The Sizewell C Project Development Consent Order Application
Planning Inspectorate Reference: EN010012

Summary of Relevant Representation from Suffolk Wildlife Trust

Suffolk Wildlife Trust 12th May 2021

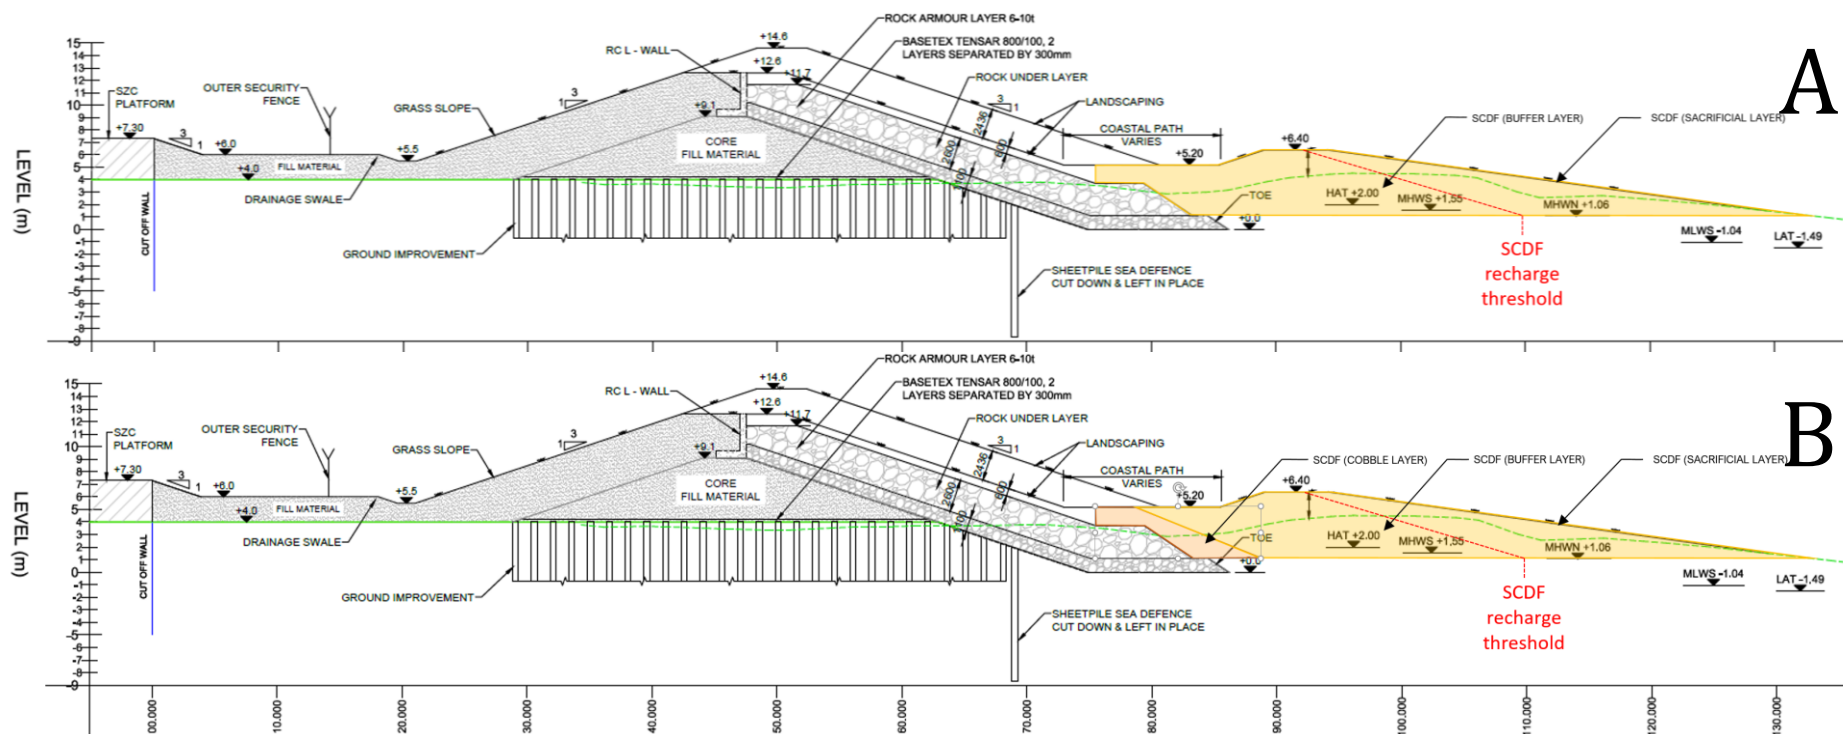
- Lack of detail on coastal defence design, making it impossible to determine medium to long-term impacts;
- Areas of marsh harrier foraging provided as mitigation will be inadequate to offset overall loss;
